PLANNING CONSULTATION RESPONSE

Application No	2026/0021
Proposal	Proposed two storey side and rear extension, and rear extension at a lower level to accommodate a gym and swimming pool
Address	53 Keresforth Hall Road, Kingstone, Barnsley, S70 6NL
Date of Consultation Reply	03/03/2026
Consultee	BMBC PROW – C Farley

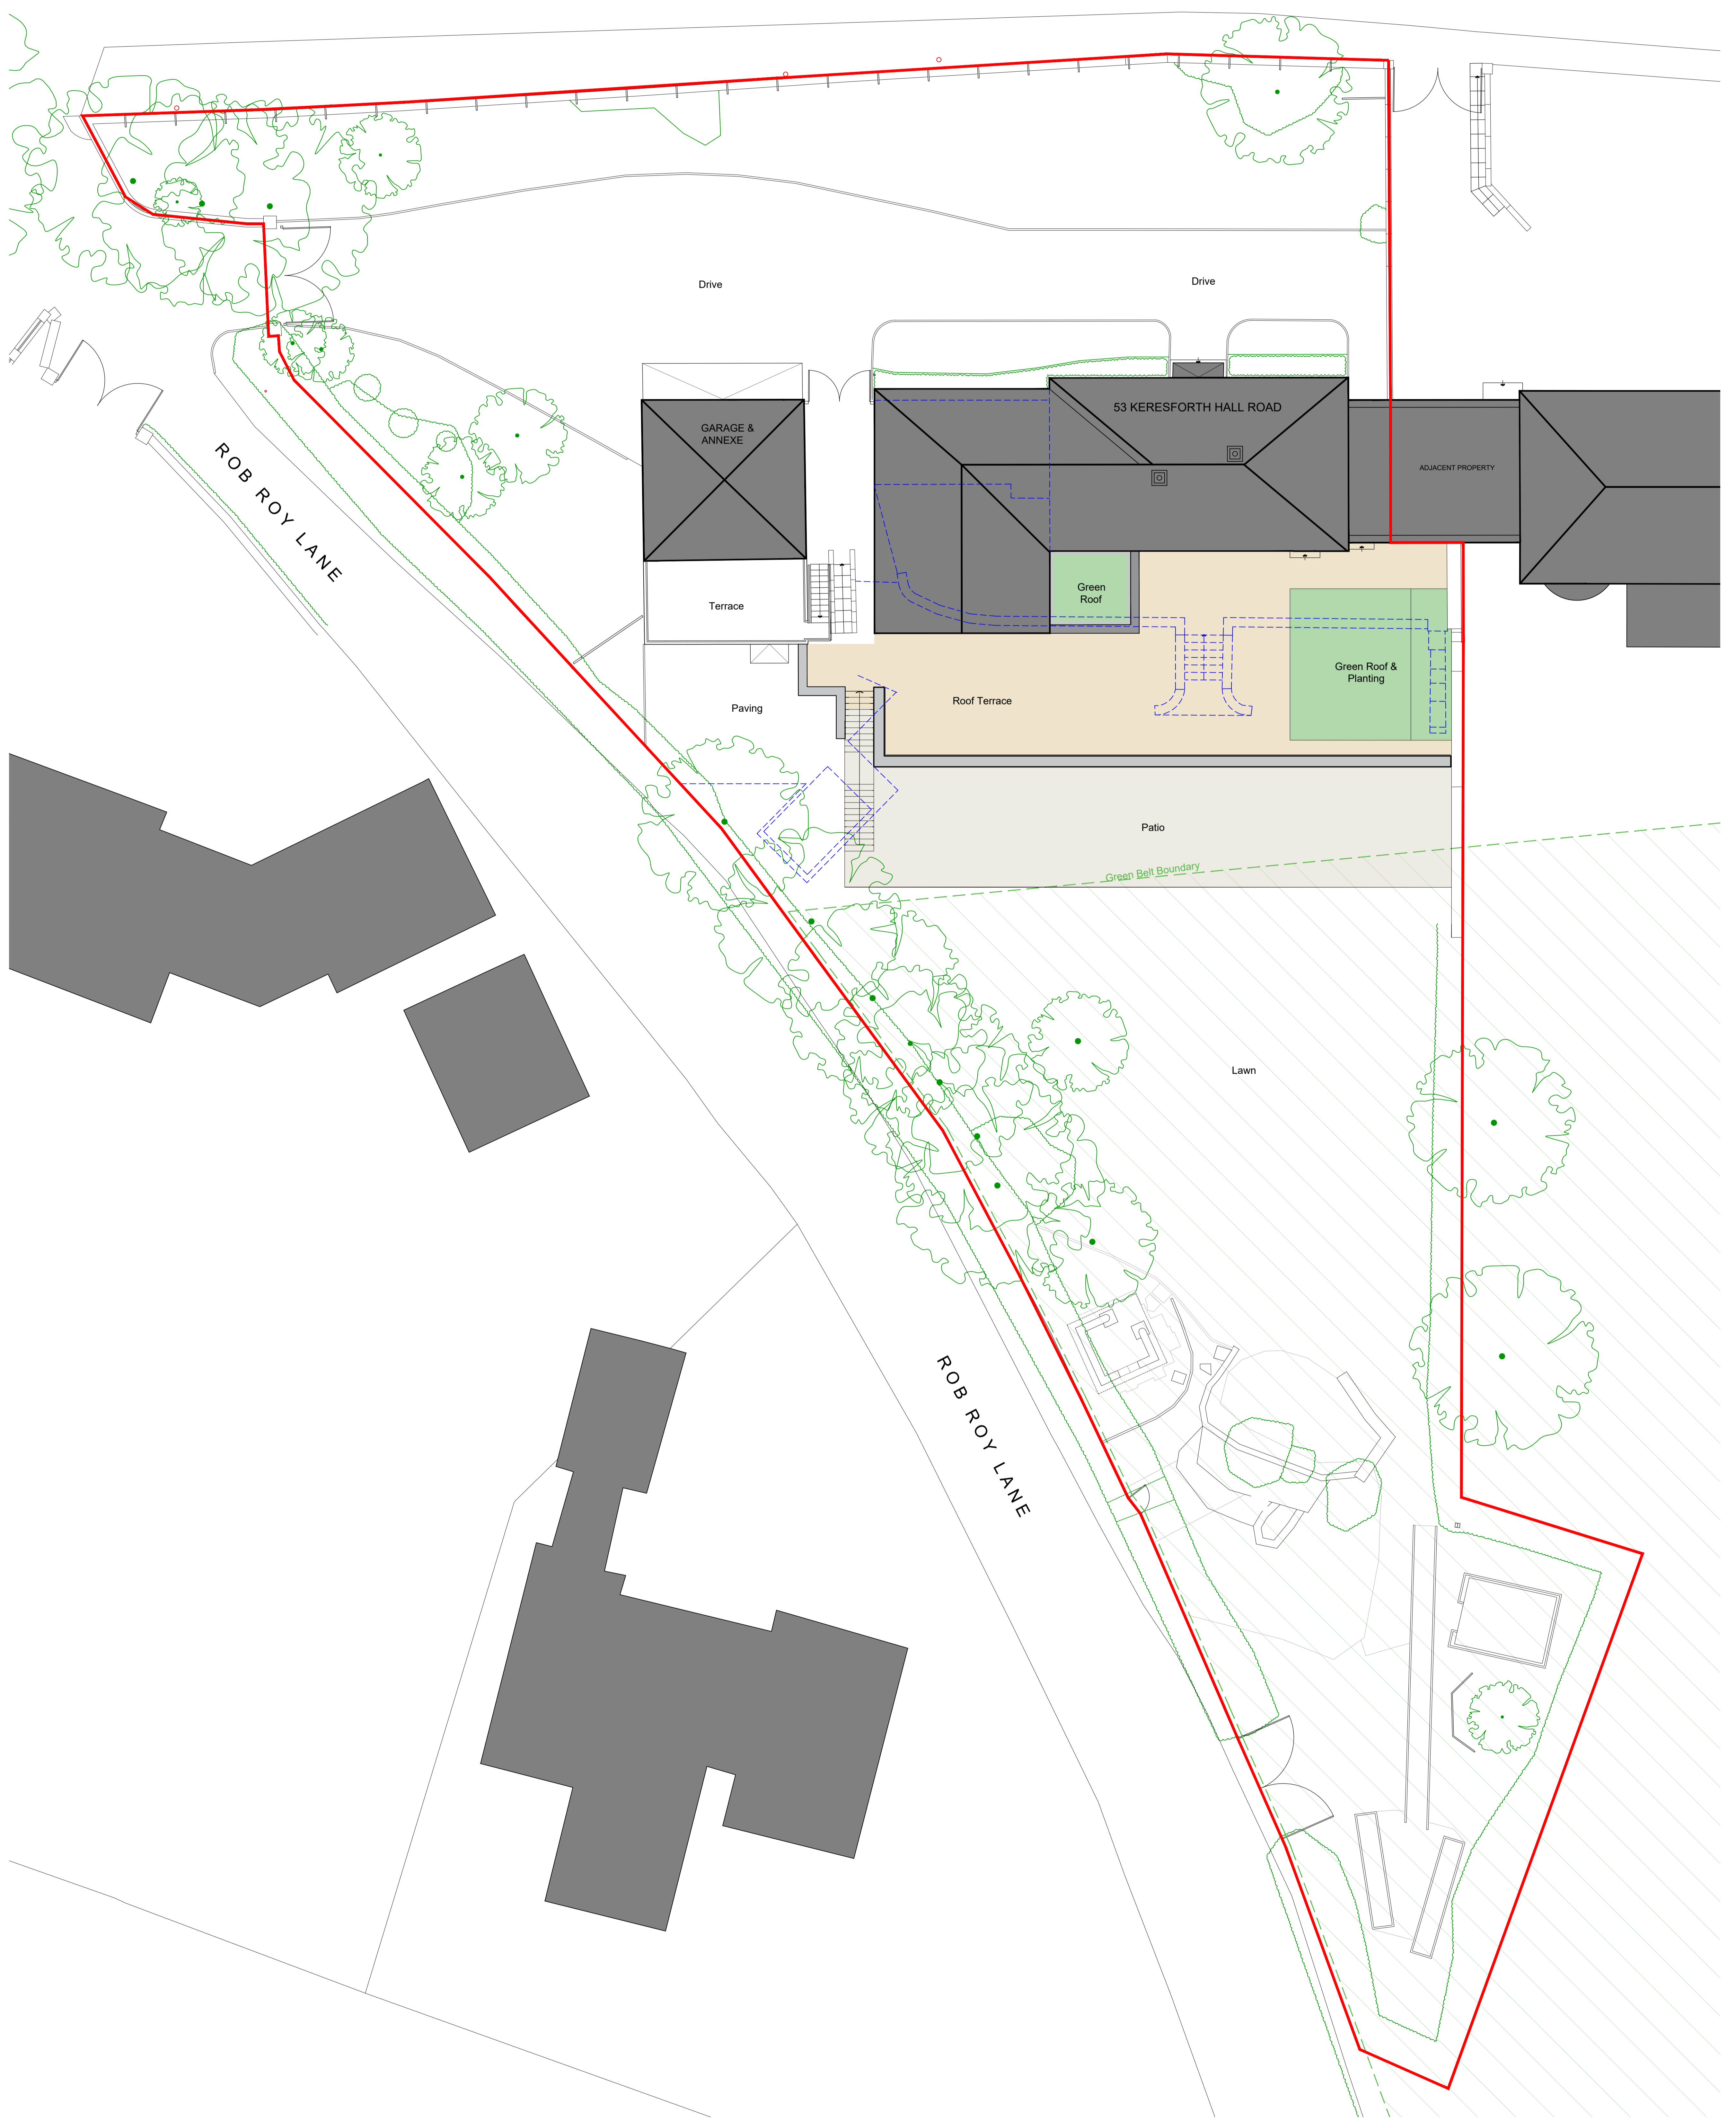
A public footpath (Barnsley FP 275) runs adjacent to the site, as shown on the screenshot below. This should remain safely open and available for the public to use at all times. If the application is accepted, the following informative should be added to any decision notice:

A public right of way (Barnsley FP 275) runs alongside the proposed development site. Safe public access on the right of way should remain available at all times, with no obstruction of or encroachment onto the width of the path and no building debris, storage of materials or parked vehicles limiting access at any time. Appropriate measures should be taken to protect the public, including fencing if necessary. If safe public access is not possible at any time then a temporary closure must be arranged, providing at least 4 weeks' notice and details of how public access will be managed. For further information contact publicrightsofway@barnsley.gov.uk.
